Listed Building Consent for Alterations, Extension or Demolition of a Listed Building

Development: Listed building consent for the replacement of double glazed aluminum / timber windows and doors with double glazed painted timber casement, sprung sash windows and matching French doors.

Location: Little Welbourne Church Lane Pagham PO21 4NX

EAST ELEVATION

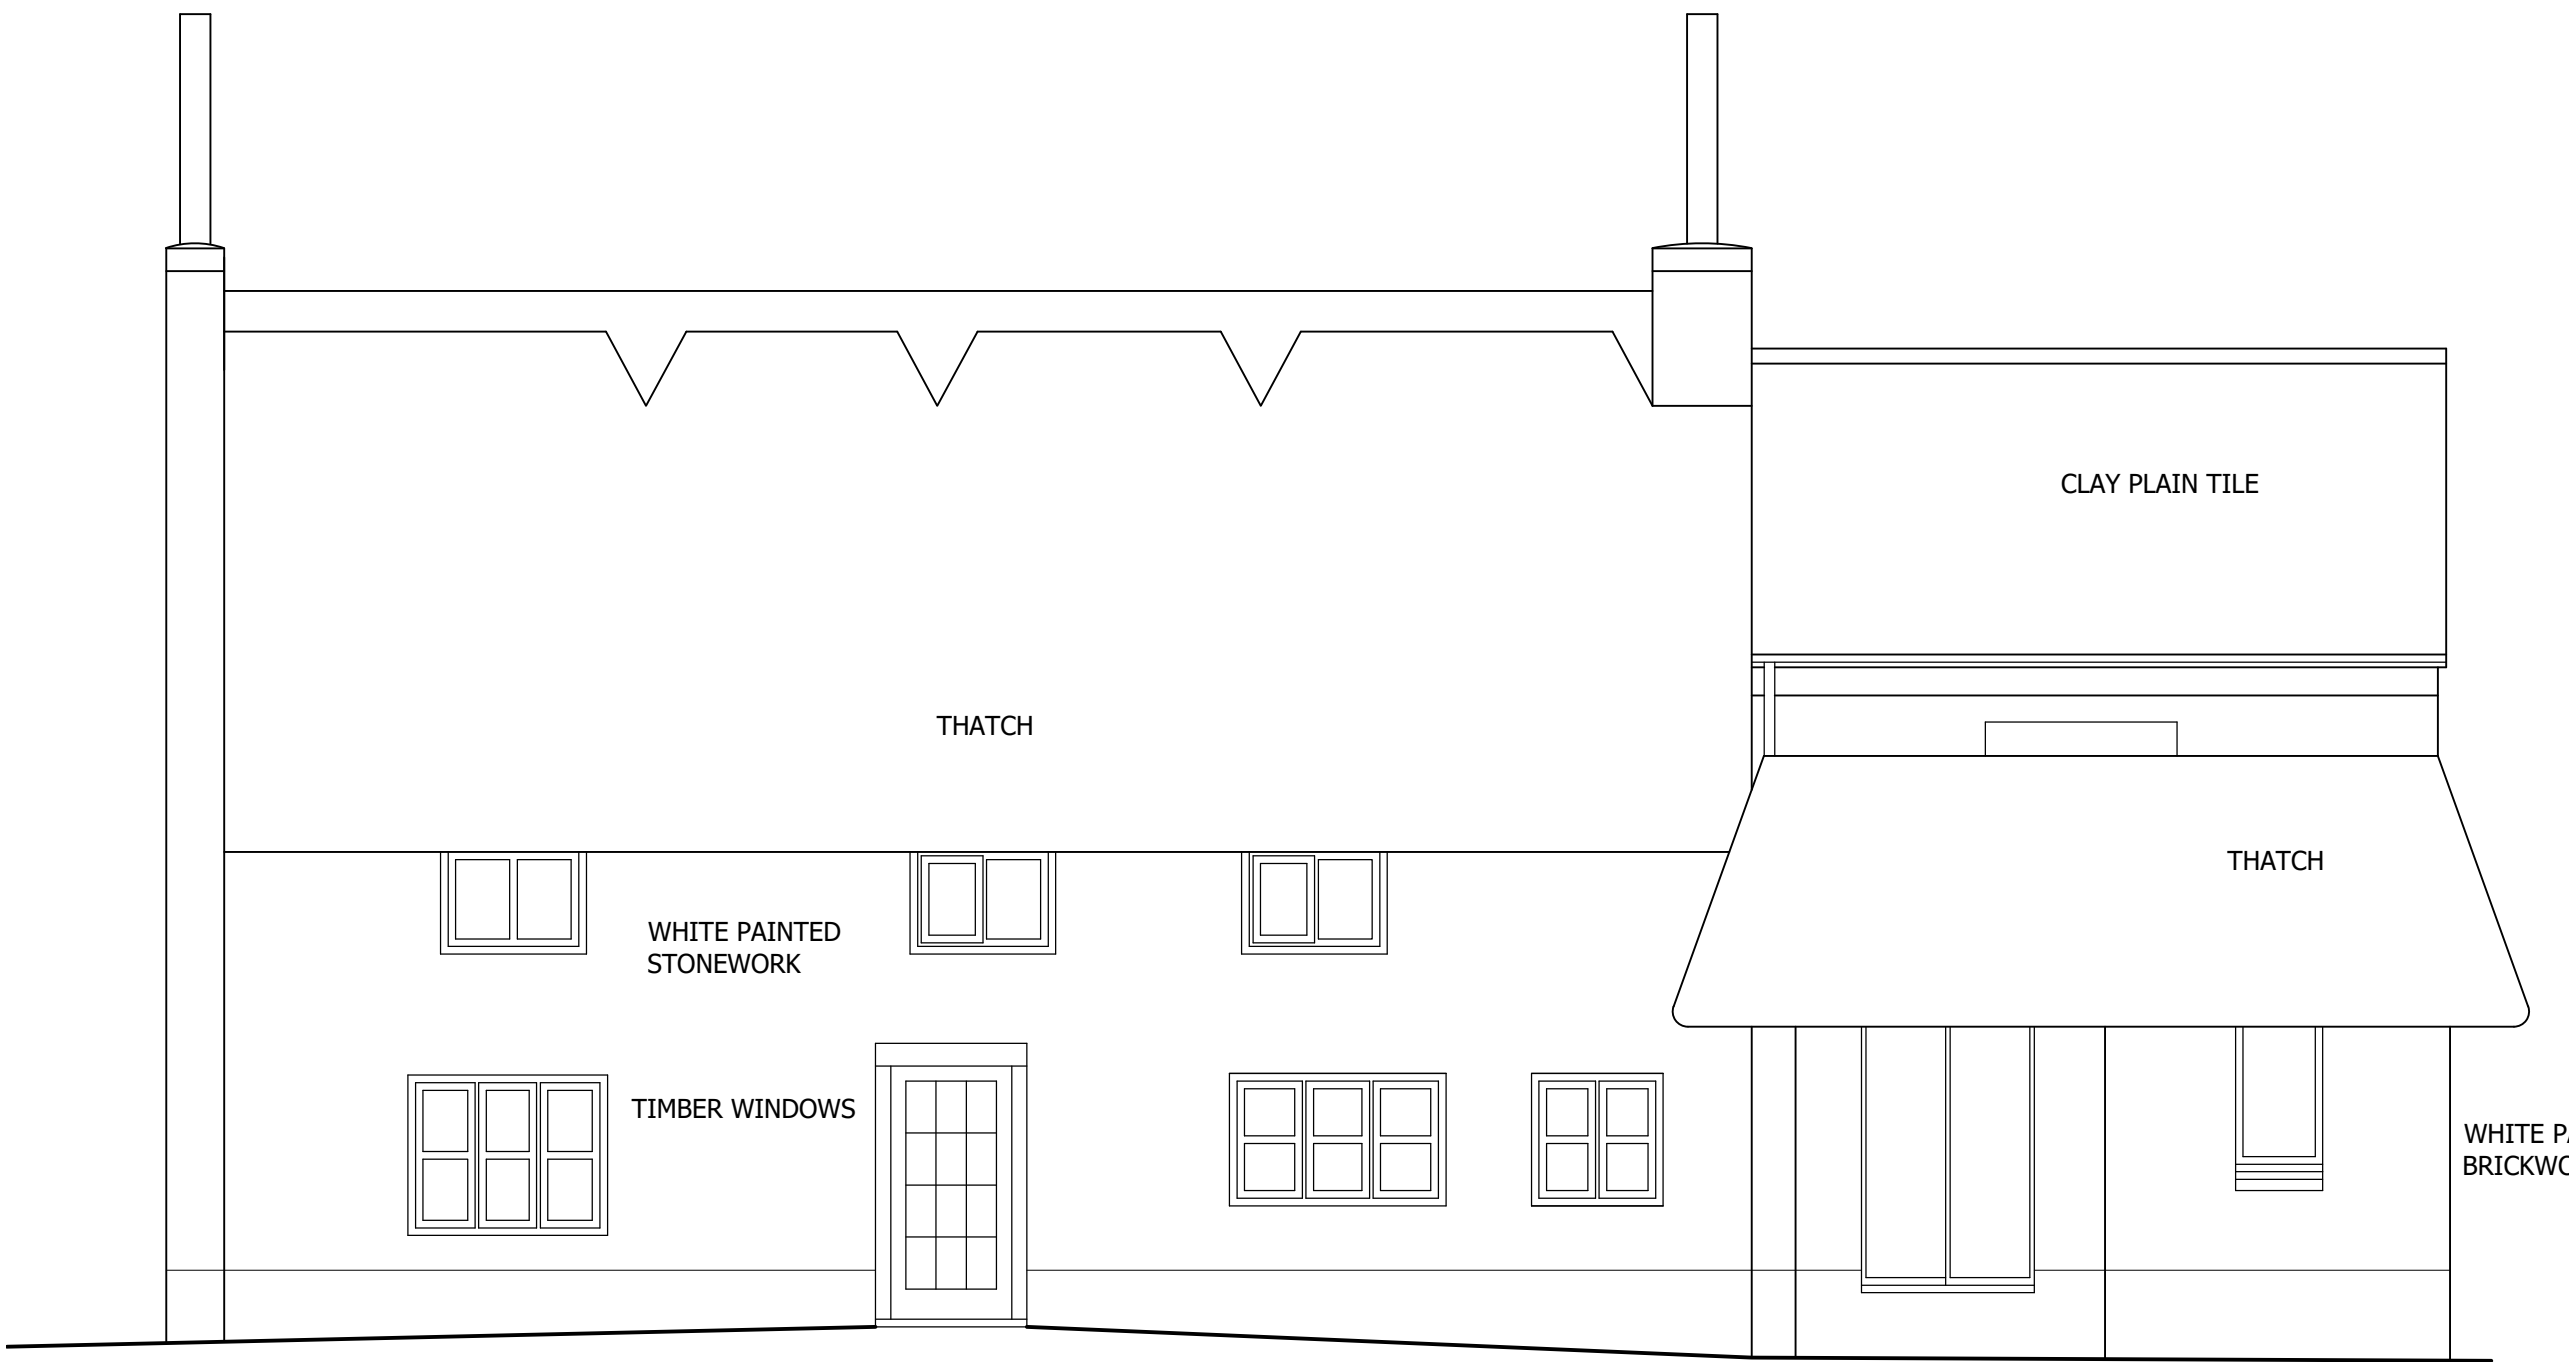
The existing and proposed east elevation plans have an inconsistency with the first floor balcony.

NORTH ELEVATION- SECTIONAL

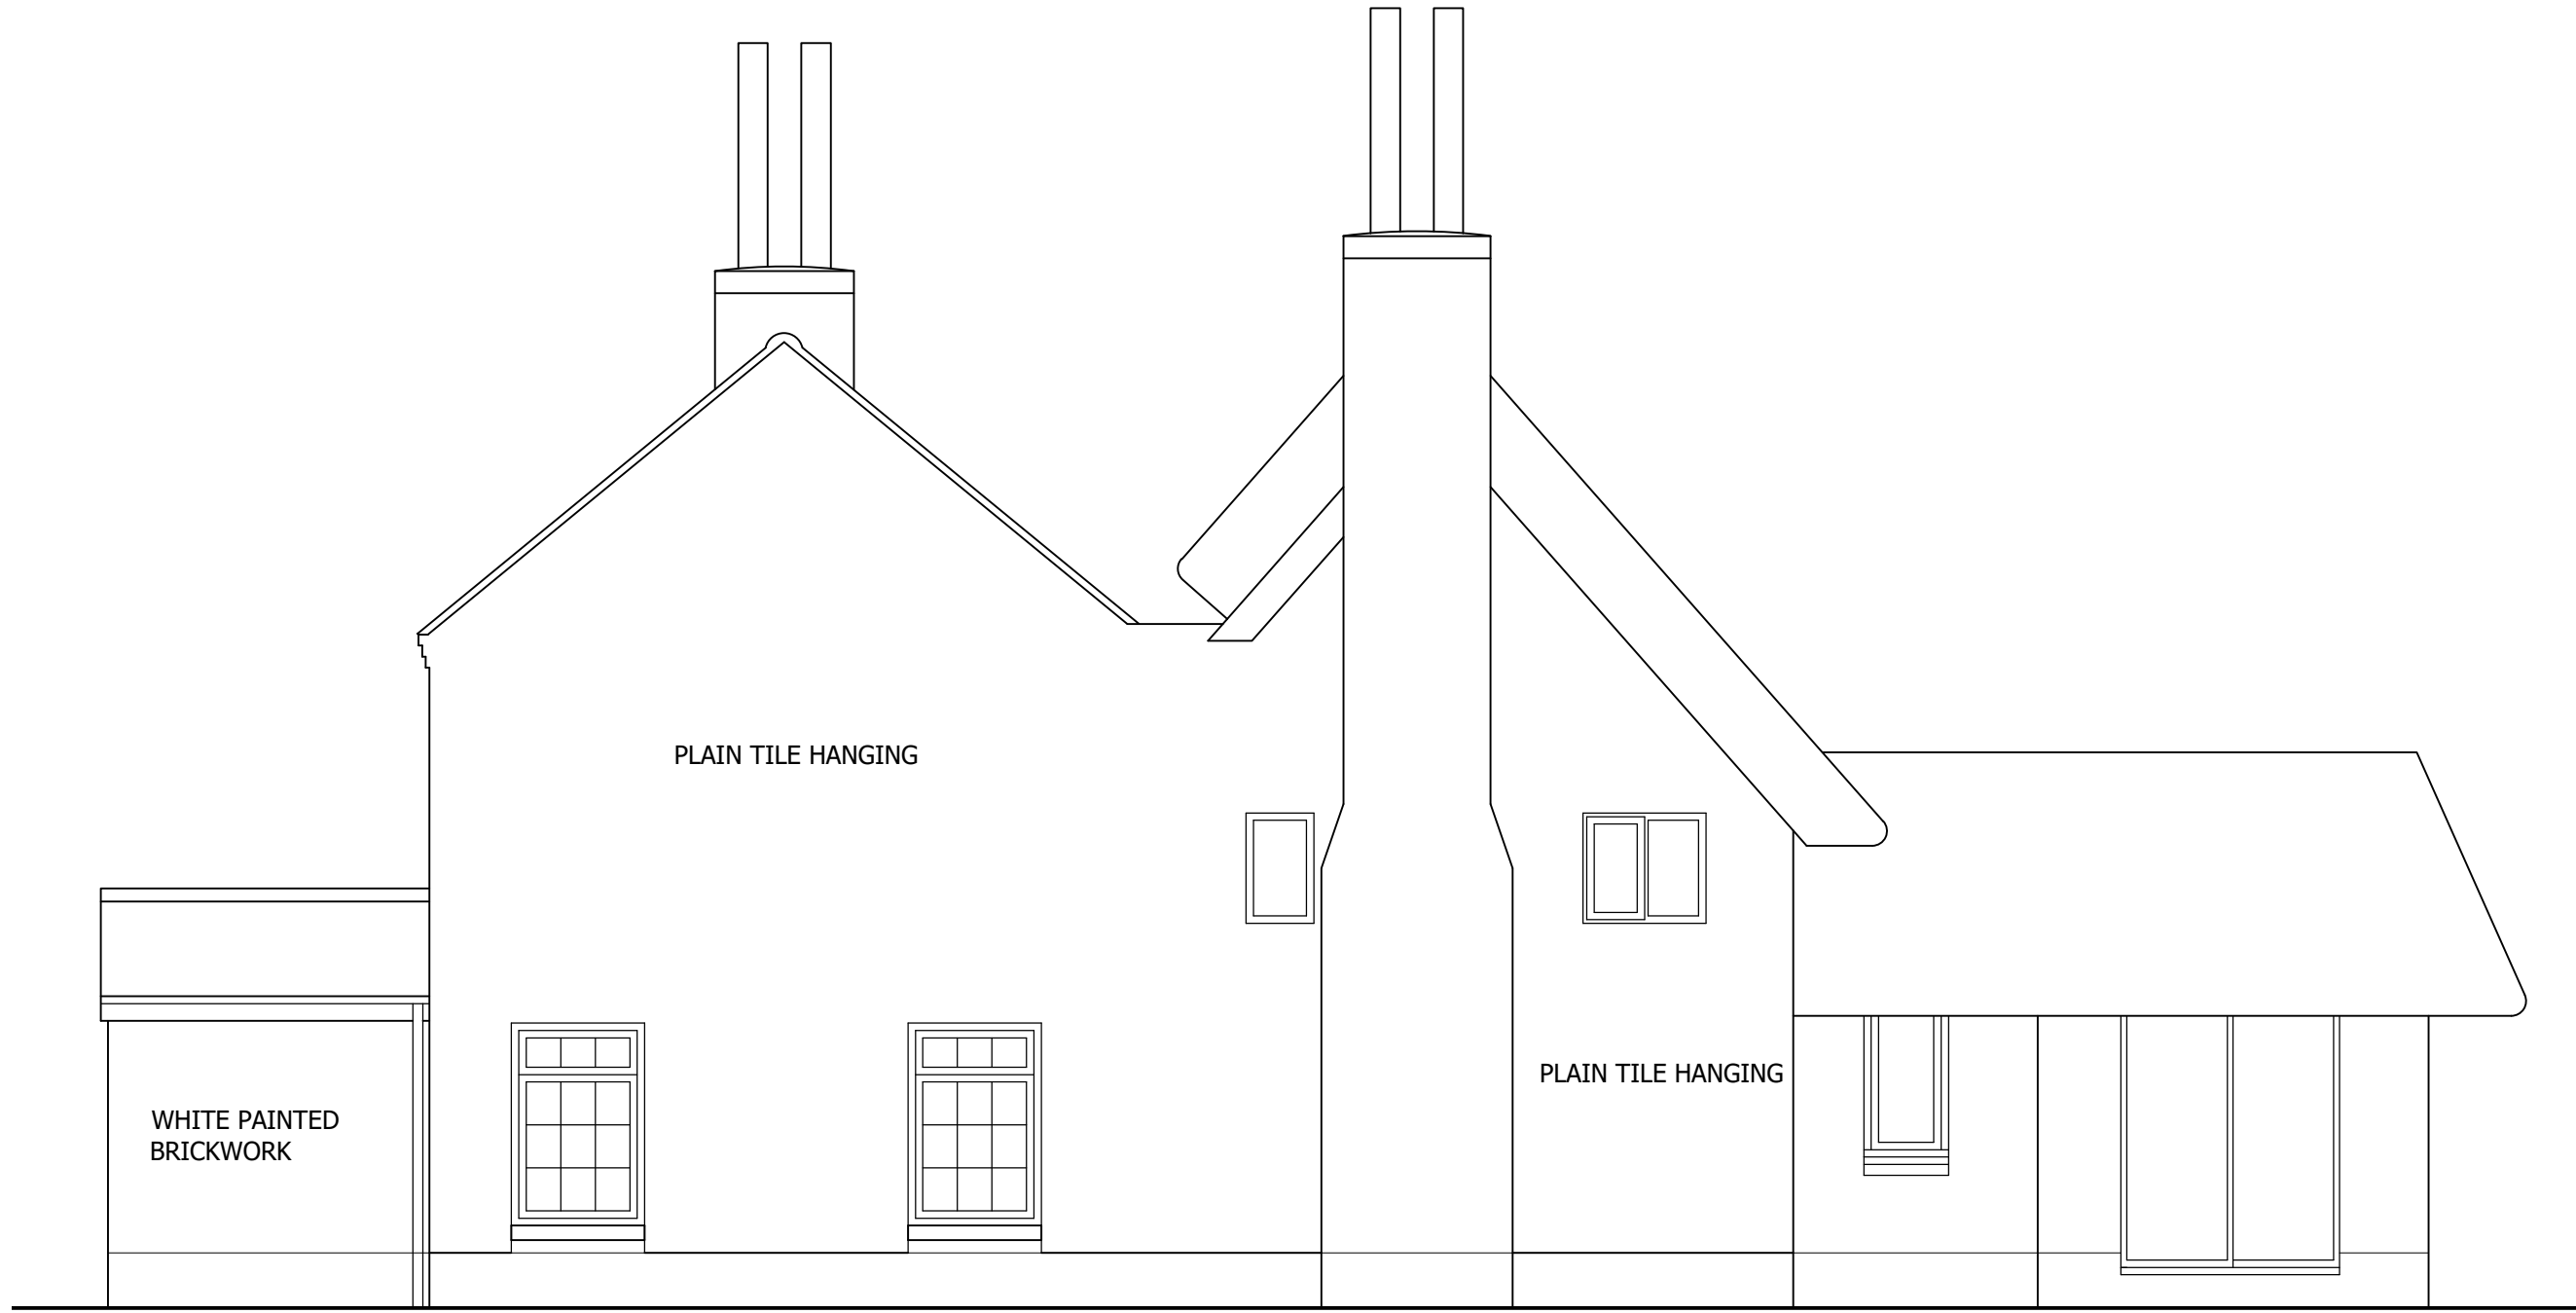
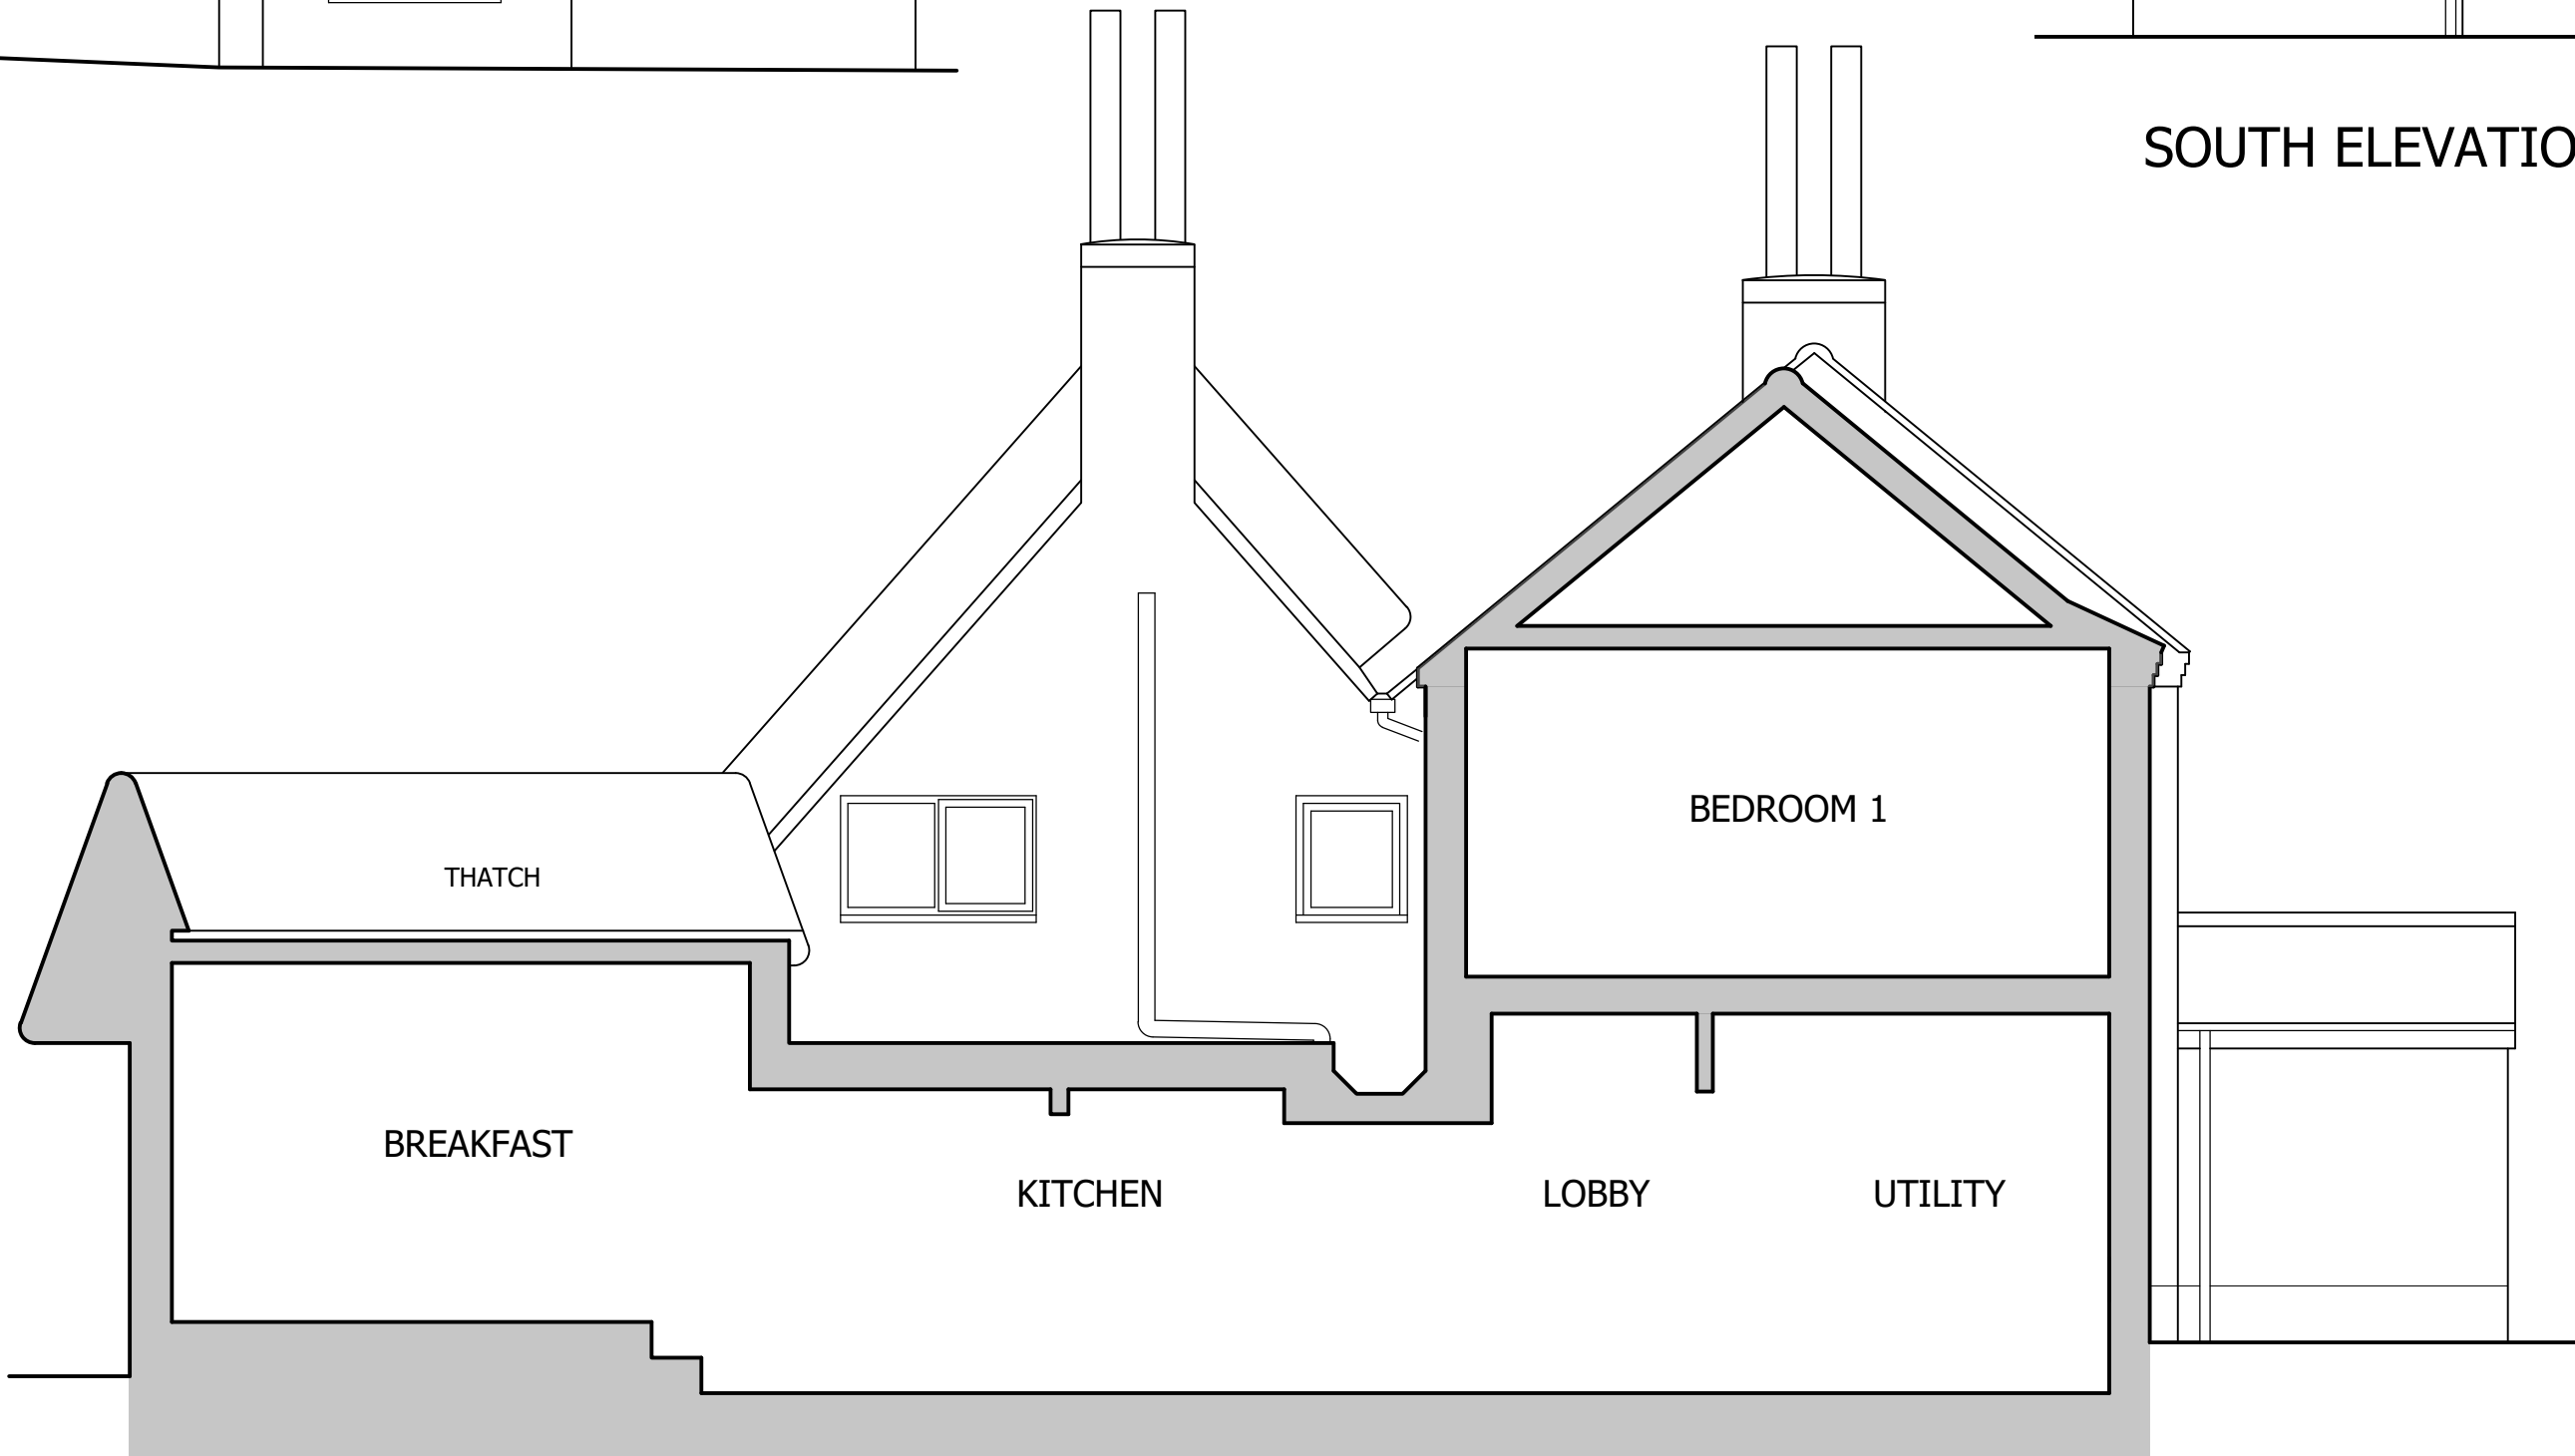
Please confirm if there will be internal changes, the existing and proposed sectional plans are inconsistent, if not then please clarify.
